Lower Thames Crossing

5.4.1.4 Draft Agreed Statement of Common Ground between (1) National Highways and (2) Kent Downs AONB Unit (Tracked changes version)

This is an Agreed Draft Statement of Common Ground with matters outstanding.

*Local Landscape Character Area boundaries of the Kent Downs AONB LCA, West Kent Downs, Sub-areas Cobham and Shorne*

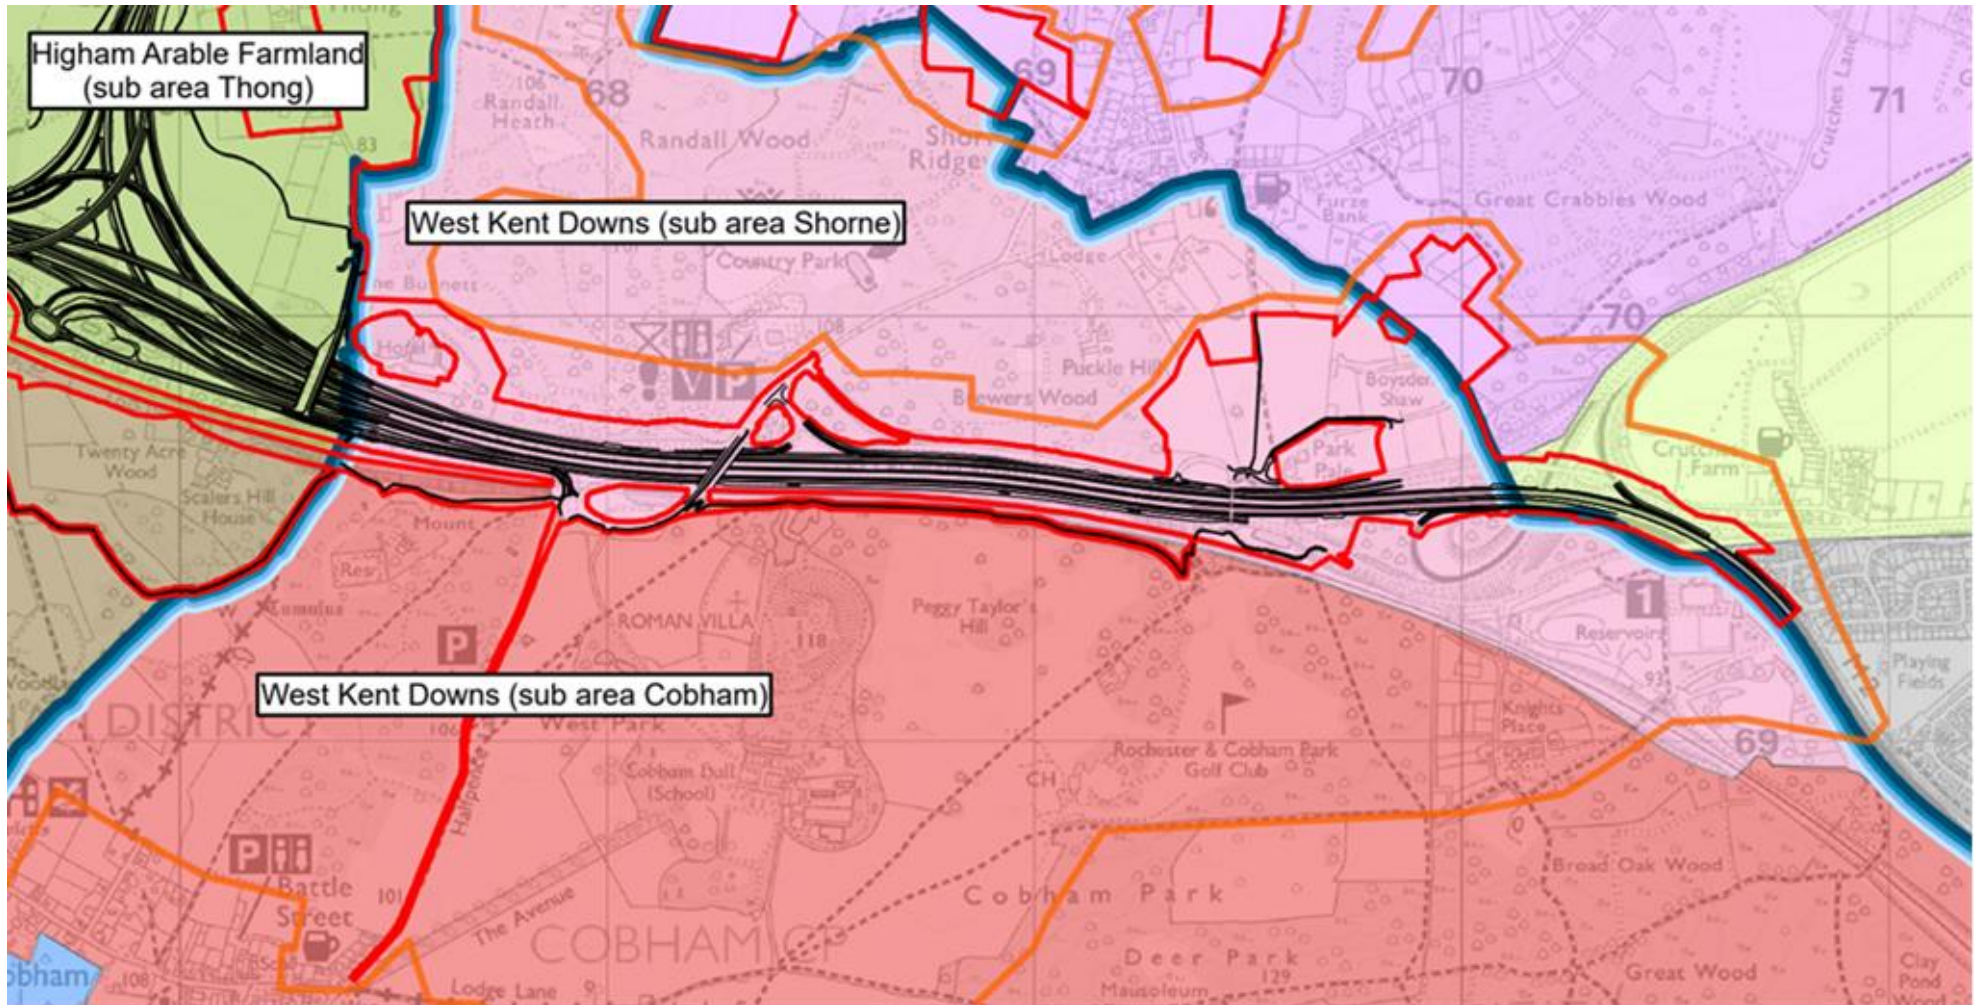
Landscape & Visual					
<u>Baseline</u>	2.1.42 <u>WR</u> <u>(DL6)</u>	<u>The LVIA has assessed the impacts on the Kent Downs AONB Landscape Character Areas (LLCA) based on an adjusted plotting of the boundaries of the Shorne and Cobham Subareas of the West Kent</u>	<u>As detailed in Appendix A of Comments on Written Representations, the boundaries of character areas identified in the studies have been used to inform the definition of the LLCAs, which have</u>	ES Chapter 7: Landscape and Visual <u>[APP-145]</u>	Matter <u>Under Discussion</u>

Topic	Item No.	Kent Downs AONB Unit Comment	The Applicant's Response	Application Document Reference	Status
		<p><u>Downs Character Areas. This re-adjustment of the boundaries results in less of the proposed works falling within the Cobham sub-area as defined in the LVIA than within the Kent Downs published LCA and conversely, a greater proportion of the works falling within the Shorne sub-area.</u></p>	<p><u>been used as a basis for the assessment of effects on the landscape at the local level. In a limited number of locations, the boundaries of the published character areas have been slightly adjusted through detailed study and analysis undertaken for the LVIA in ES Chapter 7.</u></p> <p><u>From the Applicant's review of the West Kent Downs (sub area Cobham) LLCA and from its site visits, it is of the view that HS1 and the associated planting strongly define the northern extent of the Cobham sub area, and it therefore made sense for the Shorne sub area to incorporate the whole width of the A2 corridor, beyond HS1. Notwithstanding this slight difference in the West Kent Downs (sub area Cobham) LLCA boundary for the purposes of the assessment, the effects of the Project are fully assessed either as direct or indirect effects within the West Kent Downs (sub area Cobham) LLCA and/or the neighbouring West Kent Downs (sub area Shorne) LLCA. The findings of these two assessments are then brought together into a combined assessment for the overarching West</u></p>	<p><u>ES Addendum [REP5-062] Comments on WRs Appendix A: Statutory Environmental Bodies [REP2-046]</u></p>
